**From:** Richard Lewis <richardl@activeplanning.co.uk>  
**Sent:** 20 December 2023 10:37  
**To:** Planning  
**Cc:** Thomas Webster  
**Subject:** 23/01080/OUT Land north of Bicester Avenue Garden Centre, Oxford Road, Bicester

**I would be grateful if you could register the following comments on planning application 23/01080/OUT: Land north of Bicester Avenue Garden Centre, Oxford Road, Bicester.**

OXFORD ROAD / MIDDLETON STONEY MINI ROUNDABOUT MITIGATION MEASURES

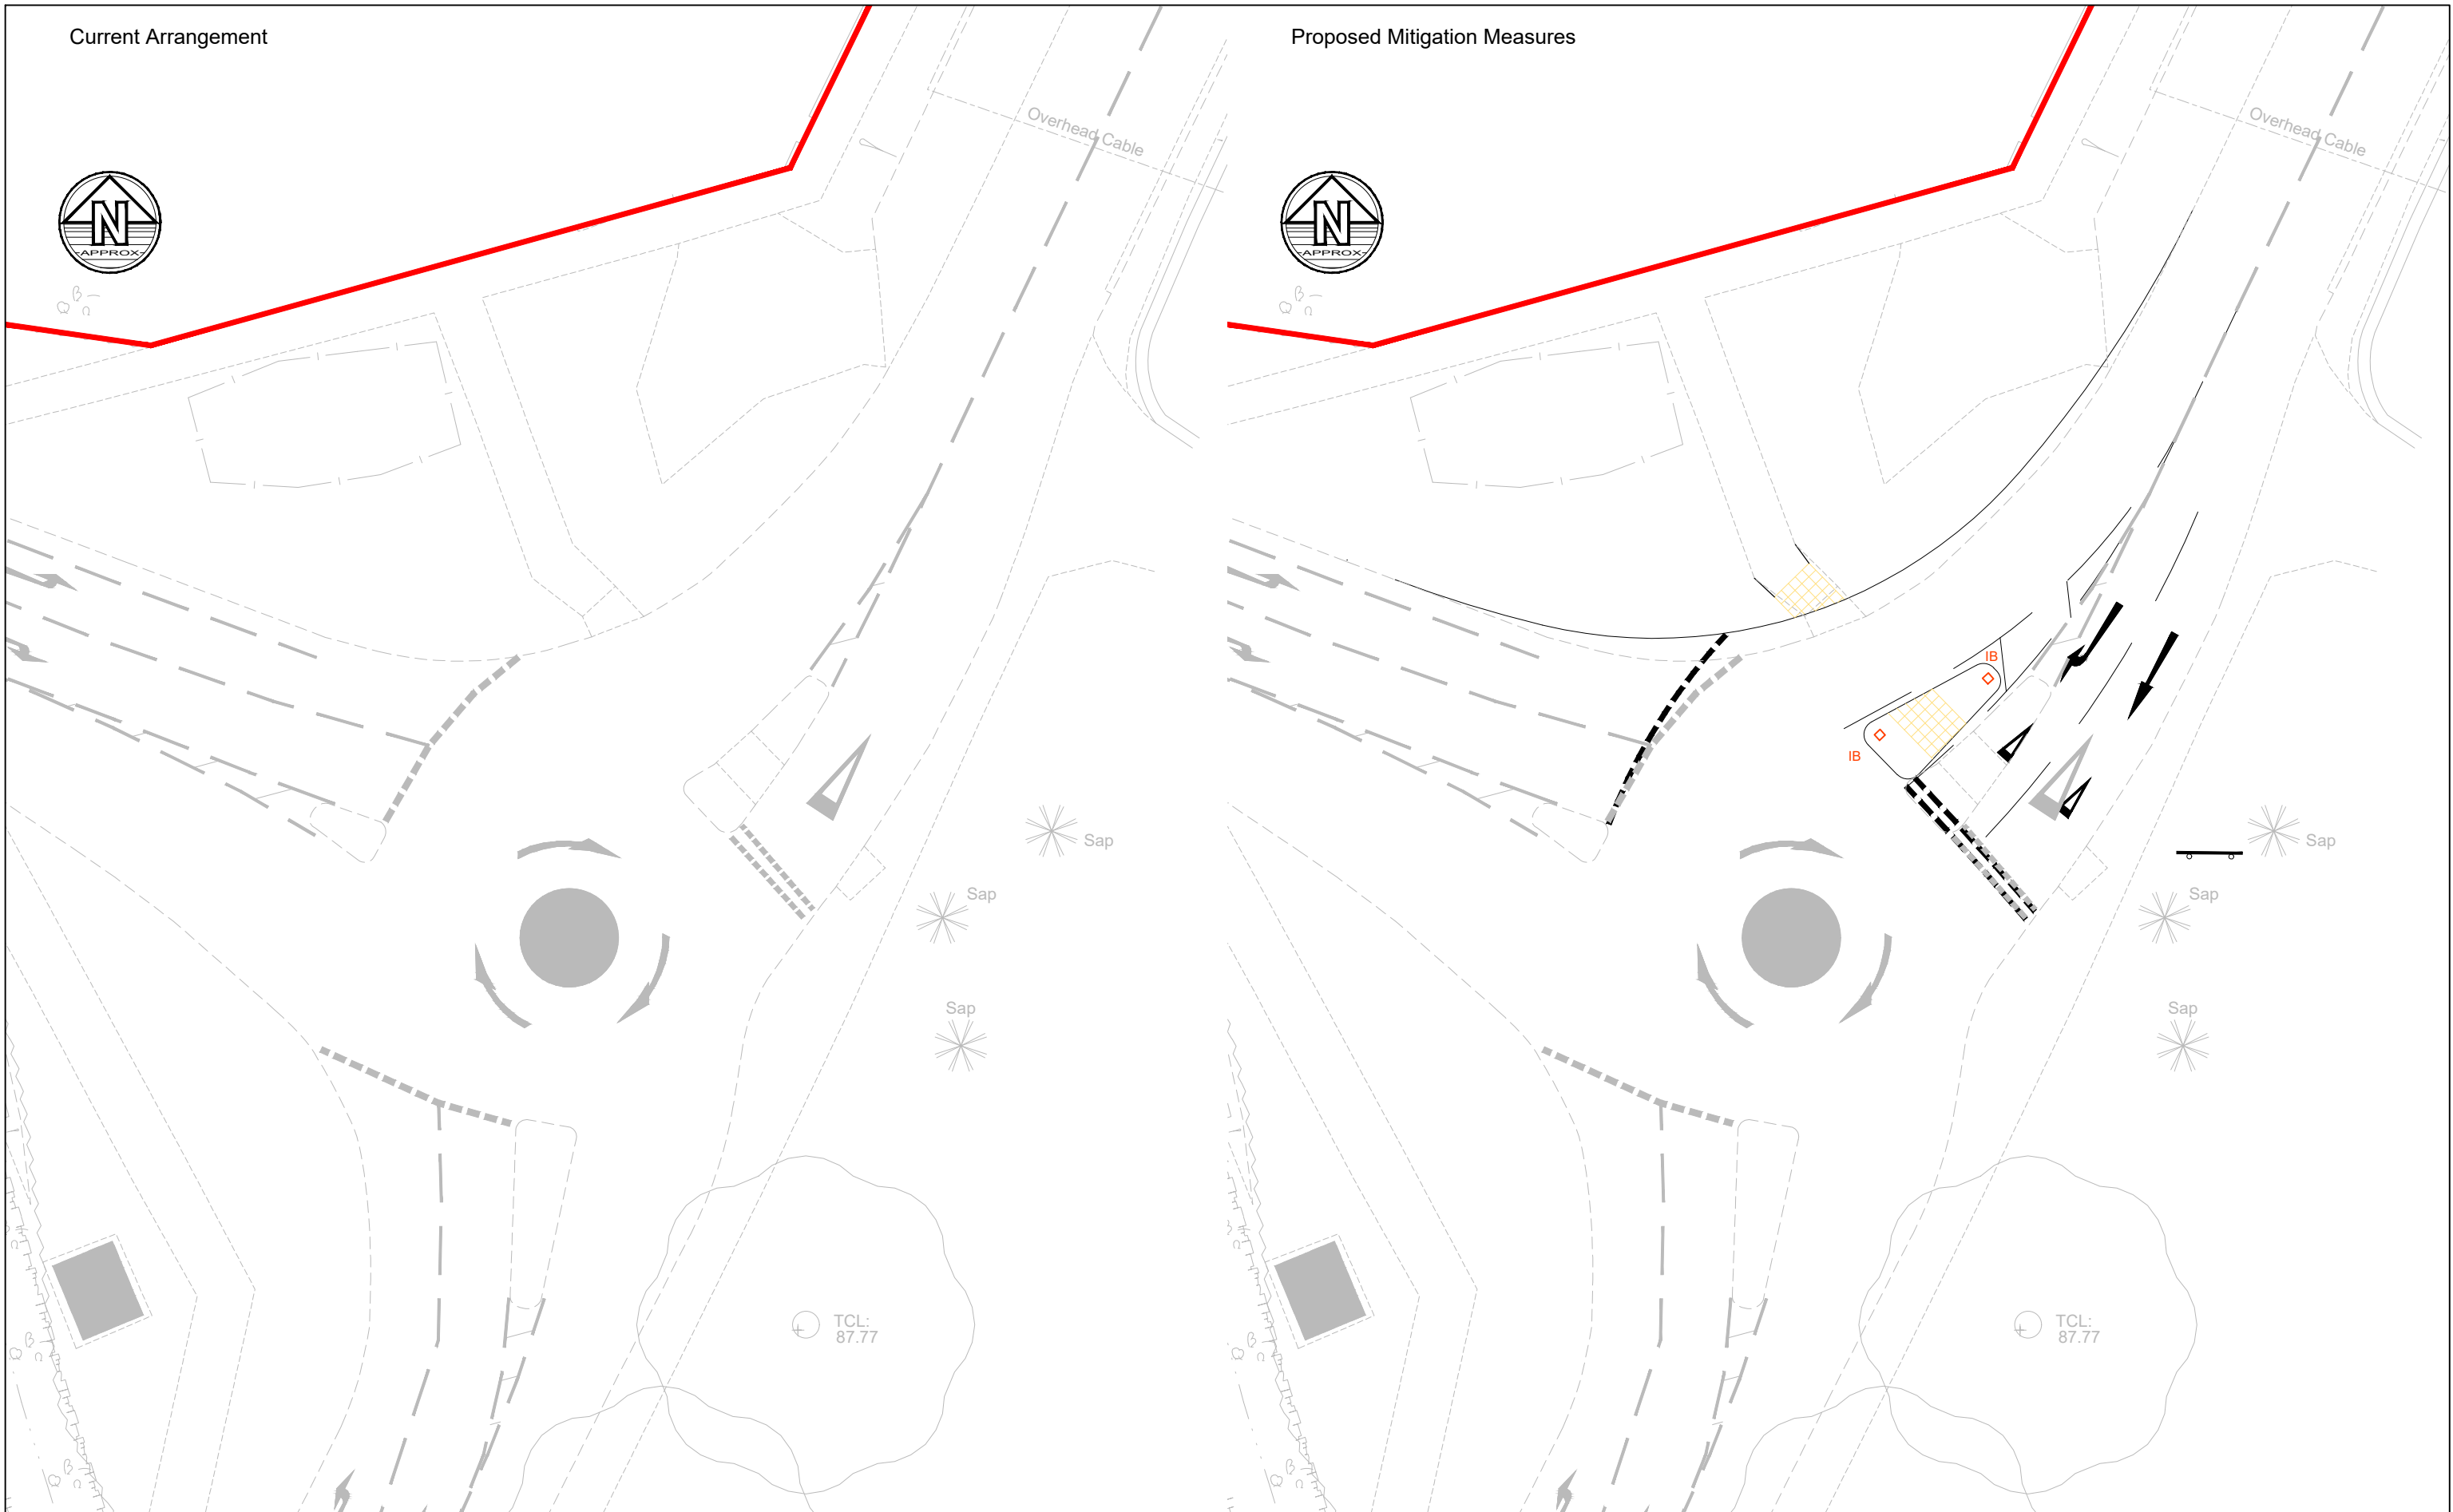
- The cycleway as existing and proposed is not designed in accordance with LTN1/20 and, given the current speed limit, would introduce safety risks to cyclists in close proximity to motor traffic travelling at 40mph. The cycleway should be segregated from pedestrians, and there should be a 1.0m buffer between the cycleway and the carriageway. A grassed buffer would also assist with preventing debris from entering the cycleway.

- The pedestrian crossings are multiple stages which we anticipate will cause considerable delay to pedestrians, contrary to the spirit and intention of the relevant policies, and do not comply with the guidance set out in Inclusive Mobility published by the Department for Transport. In the light of the Council's Public Sector Equality Duty the designs should be reviewed and amended to ensure full accessibility prior to any approval given. The layout and completed scheme should be assessed by an NRAC accredited Accessibility Auditor.

I **OBJECT** to the proposal because the proposed layout does not include a LTN1/20 cycleway connection to the new housing developments to the west. Instead, there is only the existing signalised shared use crossing in two stages. The proposed multi-stage signalised crossings will continue considerable delays to pedestrians due to multiple crossing points.

- The development shall not proceed until such time as the junction is fully implemented in accordance with approved walking and cycling infrastructure layouts which are confirmed by an independent Accessibility Auditor and design engineer as fully compliant with Government design guidance as set out in Inclusive Design and LTN1/20.

- Developer contributions and obligations are sought to ensure the delivery of LTN1/20 compliant segregated walking and cycling infrastructure (a) along the westernmost boundary of the site, alongside the A41; (b) from the junction northbound along the A41 towards Bicester, with a minimum distance specified; and (c) between the development site and the retail park and new housing developments to the west of the A41, connecting with the extant road network.
